# CITY OF ALBUQUE

March 28, 2022

**Re: Dutch Brothers – 3615 Hwy 528**  
**ESC Plan Engineers Stamp Date: 3/23/2022 – A14E019**

SEDIMENTATION/SILT FENCE WITH WIRE SUPPORT (SF)
N.T.S.

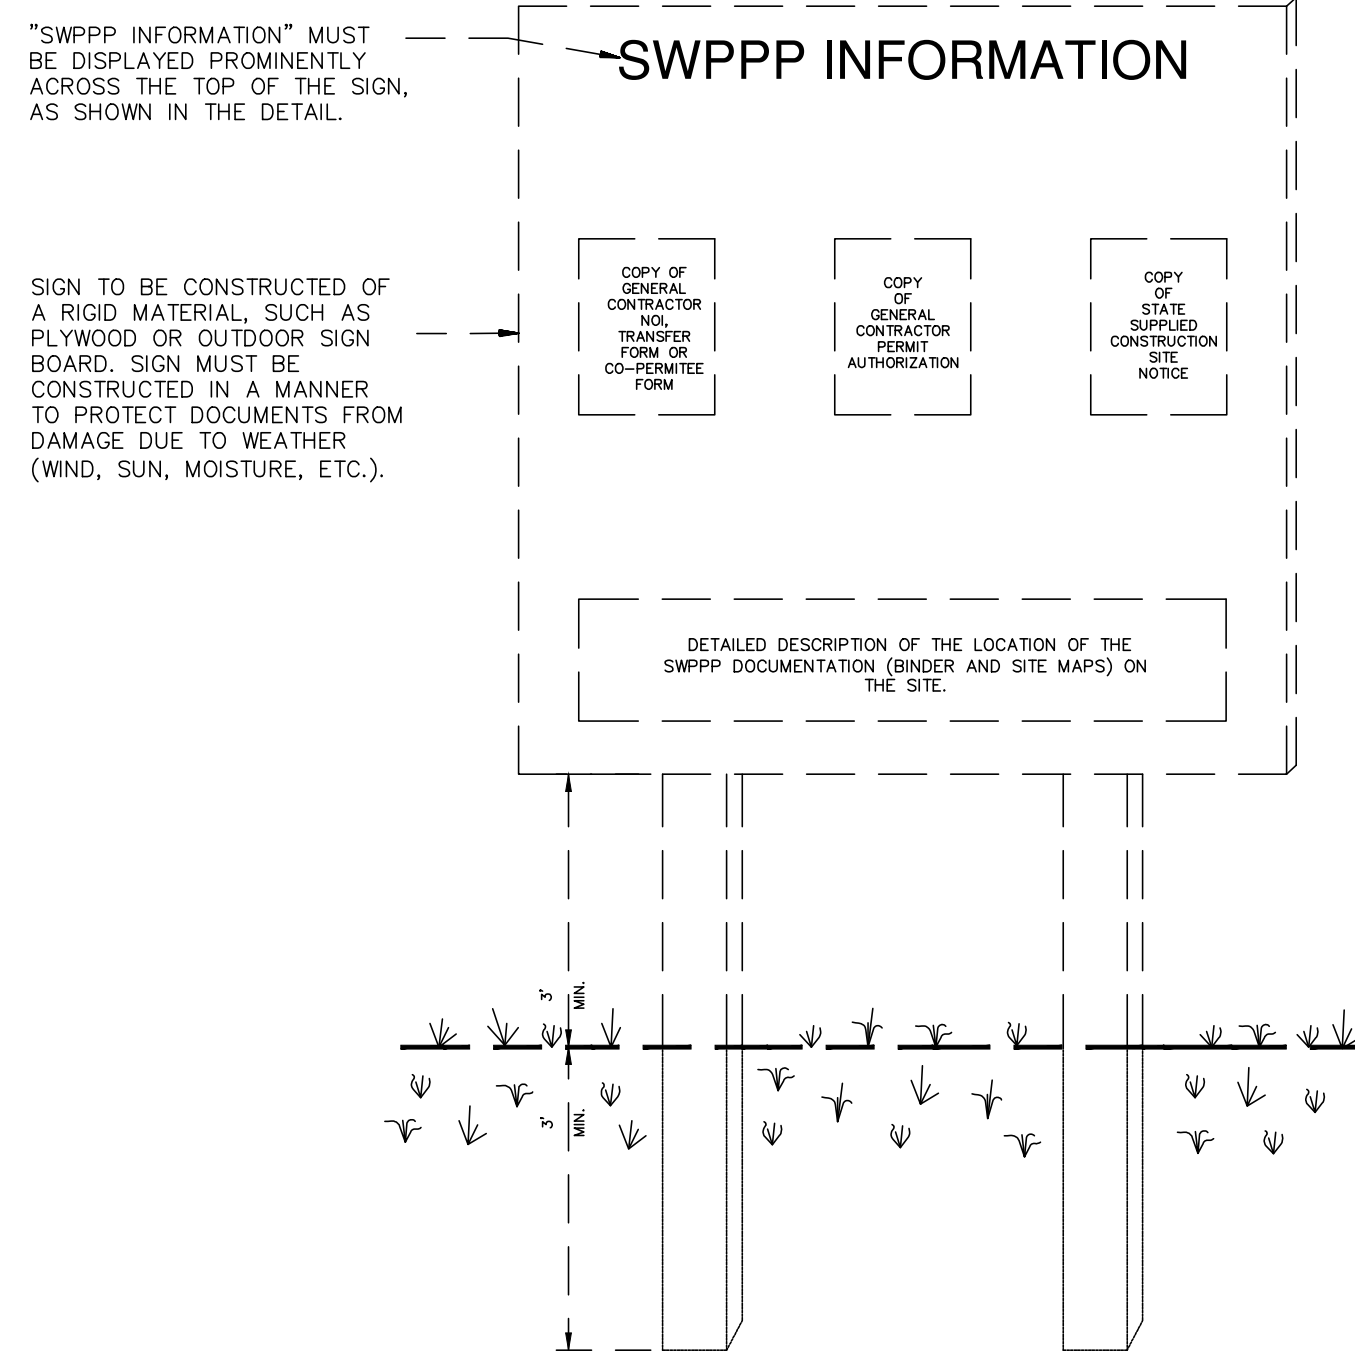
1. The limits of disturbance isn't shown. It must include all frontage improvements (CGP 7.2.4.b.i);
2. I can't tell the difference between building, sidewalk, asphalt, and dirt on the ESC Plan. These structures must be clearly identified in the SWPPP per CGP 7.2.4.b.vi. The same information is required in the ESC Application. You may attach a copy of the Site Plan to both the SWPPP and the ESC Application to address this requirement.

3. The SWPPP must include site-specific interim and permanent stabilization per CGP 9.4.1.c.i. The Landscape Plan and Work Order sheets can be used to satisfy this requirement and should be submitted separate from the ESC Plan with the application to the Stormwater Quality Section of the Planning Department and they should be included in the SWPPP. Provide a specification on the ESC Plan for any disturbed areas not covered by the Landscape Plan or Work Order sheets.

5. Update the engineer's stamp date each time the plan is changed.
